**Town and Country Planning Act 1990 (As amended)  
Town and Country Planning (General Permitted development) Order 2015 Schedule 2 Part 1 Class A**

**Prior Notification for a Permitted Development (Householder)**

**Development:** Notification under extended permitted development rights for a single storey rear flat roofed extension, extending 6m beyond the rear wall of the original dwelling house, with a maximum height of 4m and an eaves height of 2.9m.  
**Location:** 28 Argyle Road Bognor Regis PO21 1DZ

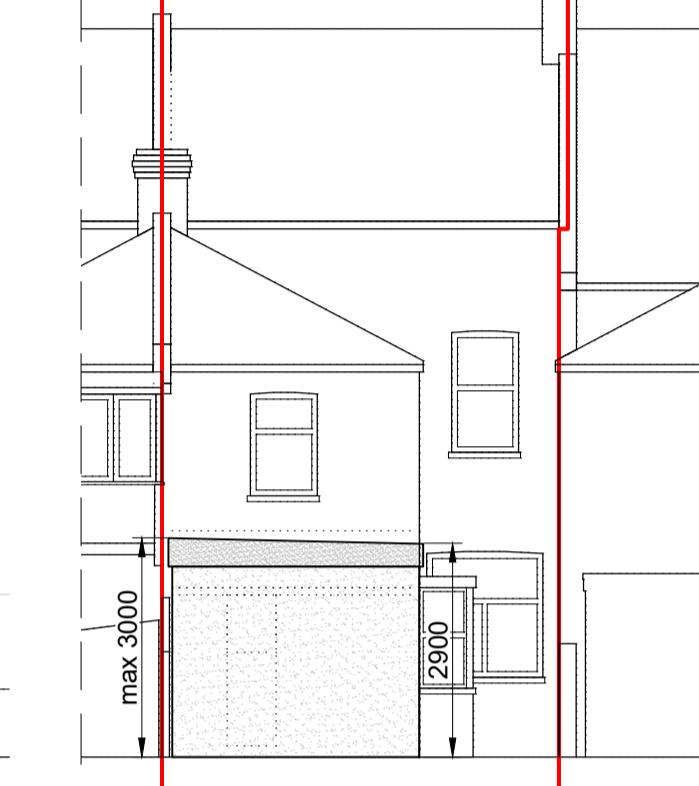
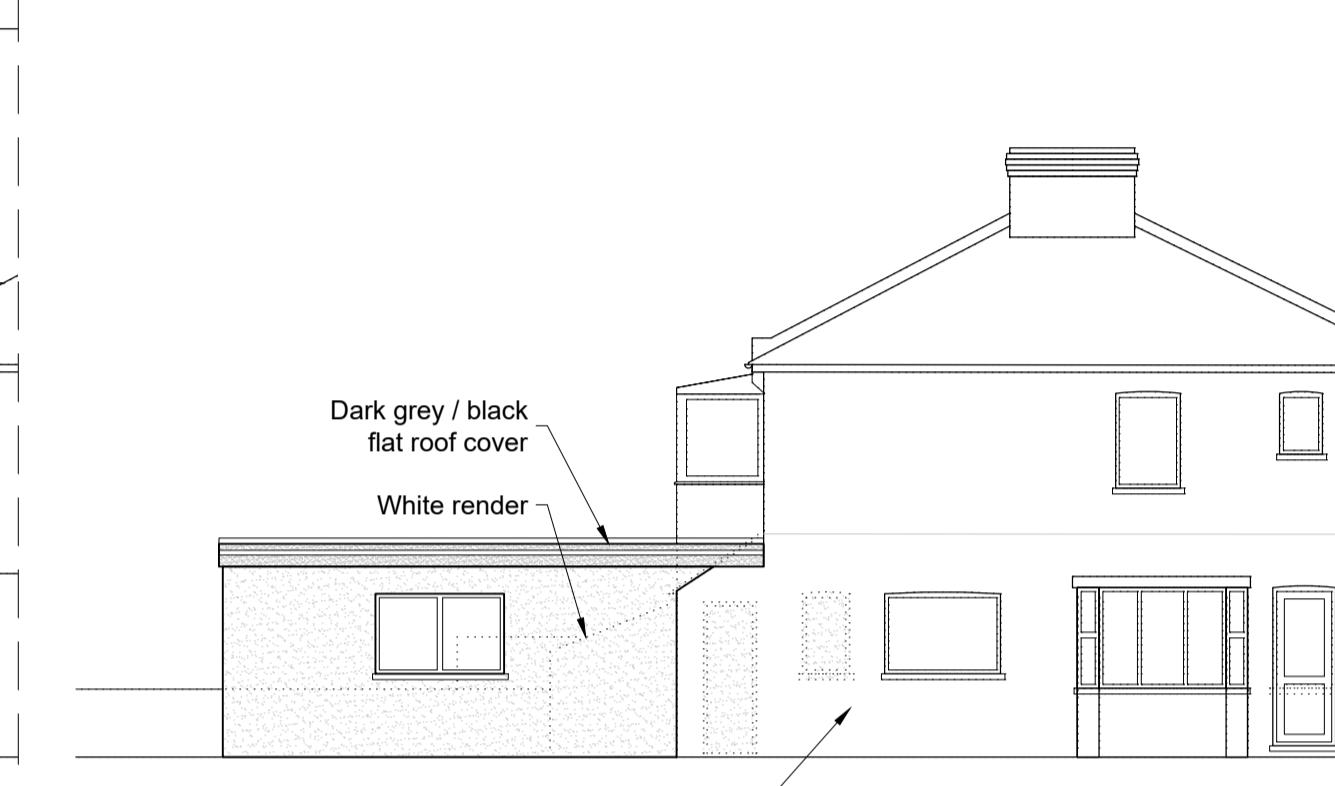
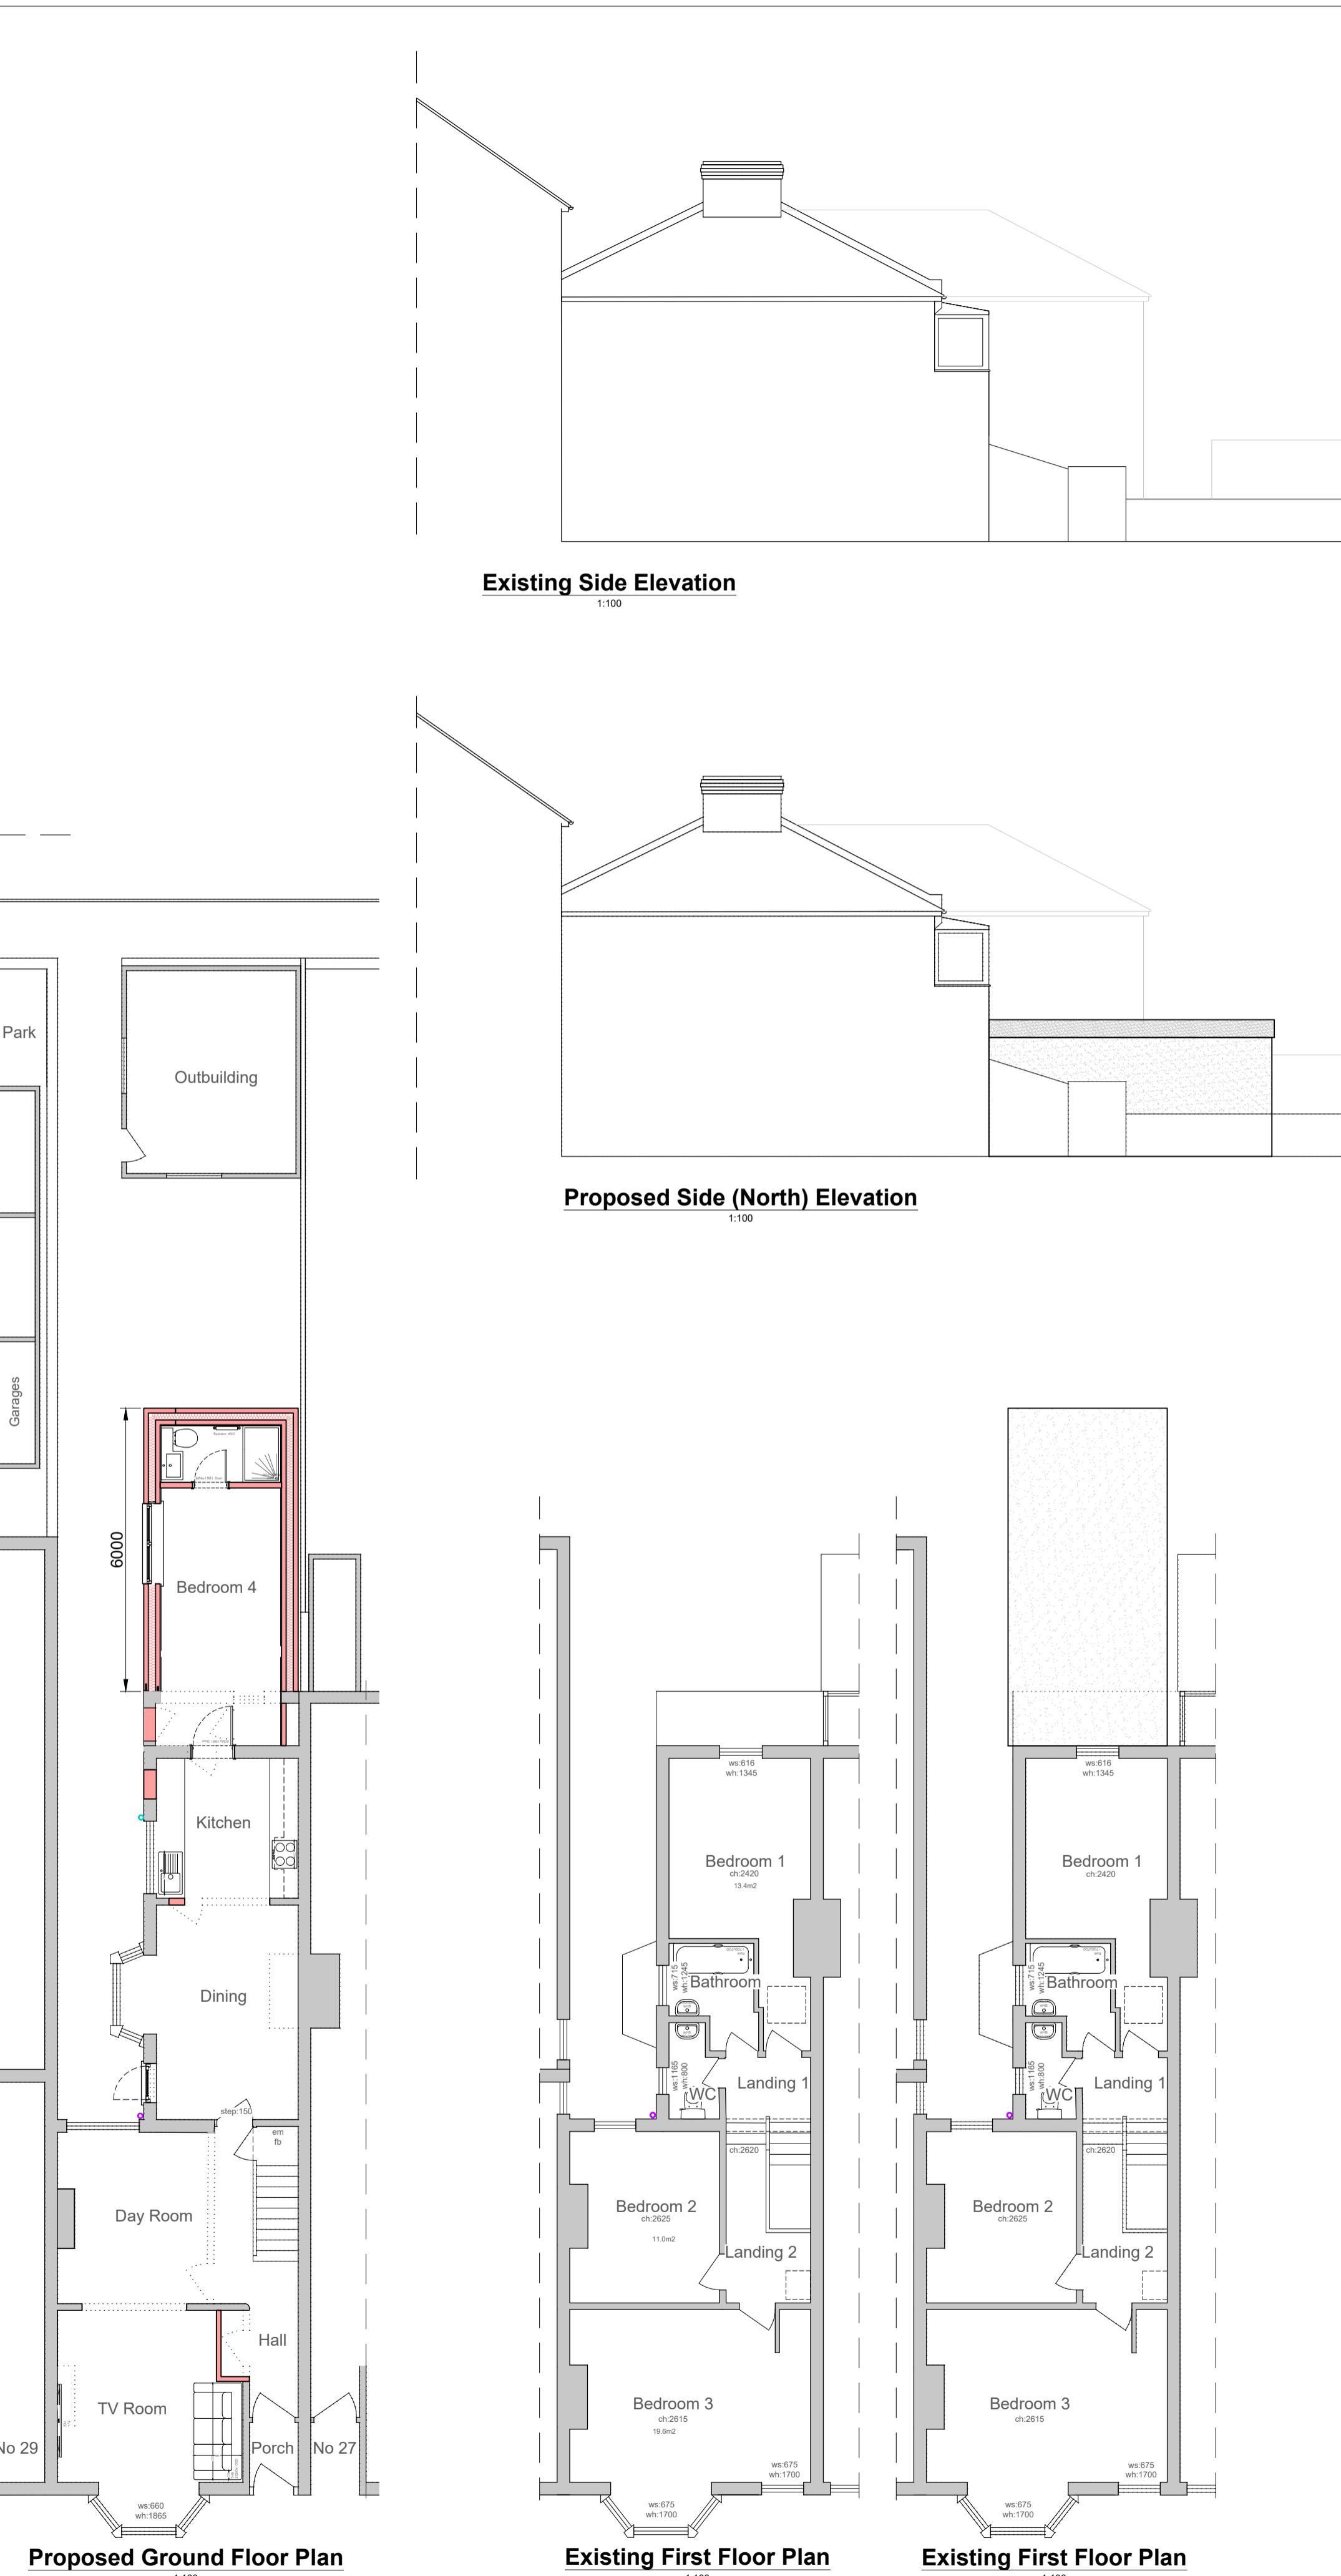
The proposed side elevation and ground floor plan do not accord. Please amend accordingly.
